**Re: Robert F. Kennedy H.S. Multipurpose Phase IA, 4300 Blake Rd. SW,
Traffic Circulation Layout, Architect's Stamp dated 9-30-13 (N10-D006)**

Based upon the information provided in your submittal received 10-01-13, the above referenced plan cannot be approved for Building Permit until the following comments are addressed:

PUBLIC IMPROVEMENTS DETAIL

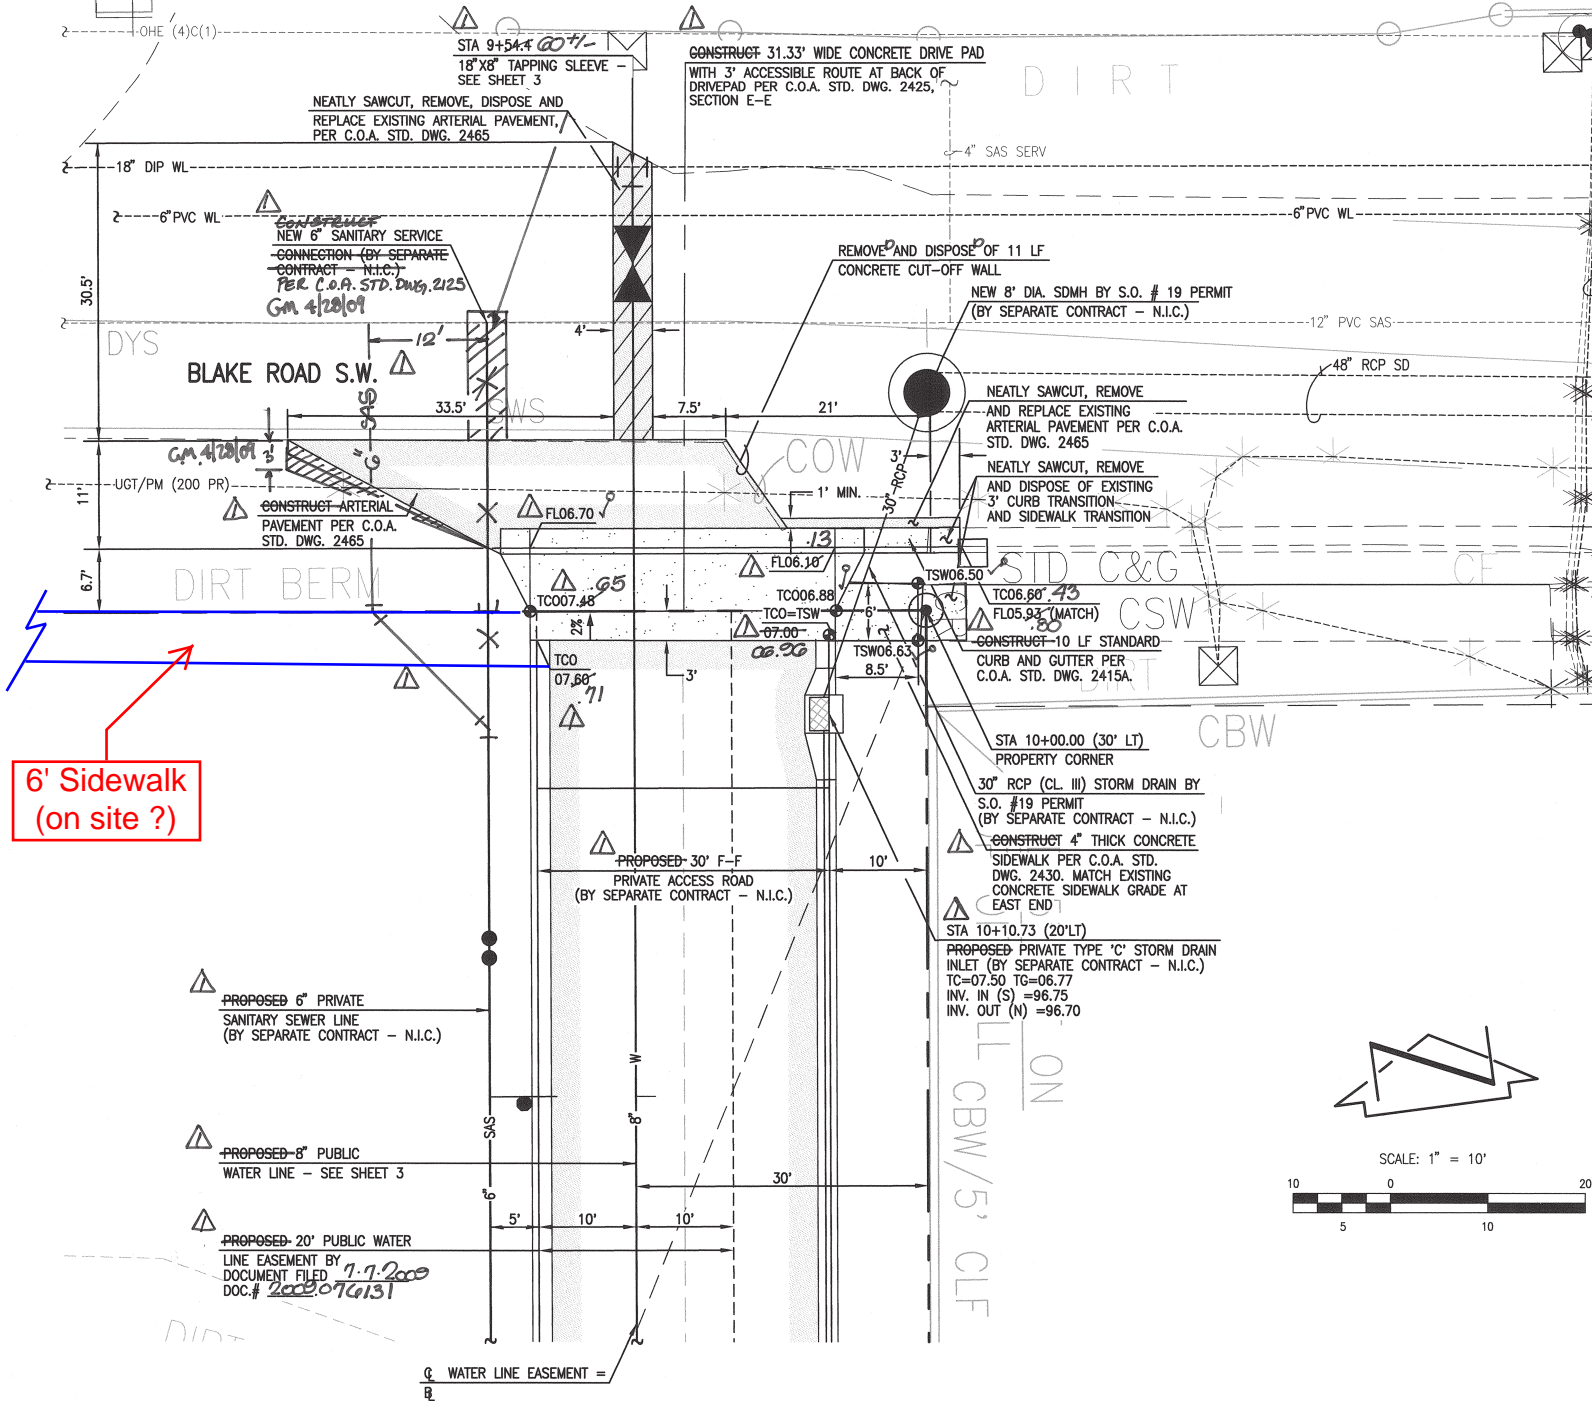
1. Permit to tie into county road?
2. Proposed edge treatment of asphalt at radius?
3. Proposed radius and width of drive pad?
4. Saw cut existing asphalt and tie-in proposed asphalt at existing grade?
5. Dowel in proposed concrete to existing concrete at sidewalk/drive pad?
6. Show limits of proposed curb and gutter and provide design details or applicable COA Std. Dwg #.
7. Surface treatment of entire drive?
8. Width of drive?
9. Show the distance between the centerline of the proposed drive pad to the centerline of Katrina Dr across Blake Rd. The DPM requires the centerlines to be less than 15 ft apart or greater than 50 ft separation.

1. Show existing gate/bollards or indicate to be removed.
2. Ramps connected to pedestrian paths must be Handicap Accessible with a minimum landing of 60"x60" between directional changes.
3. Width of entrance and drive aisle?
4. If the site has left turn access, the drive pad has a 36-foot minimum width.
5. Proposed tie-in of existing to proposed concrete infrastructure?
6. Existing chain link fence being removed or is a gate/opening being provided at pedestrian sidewalk?
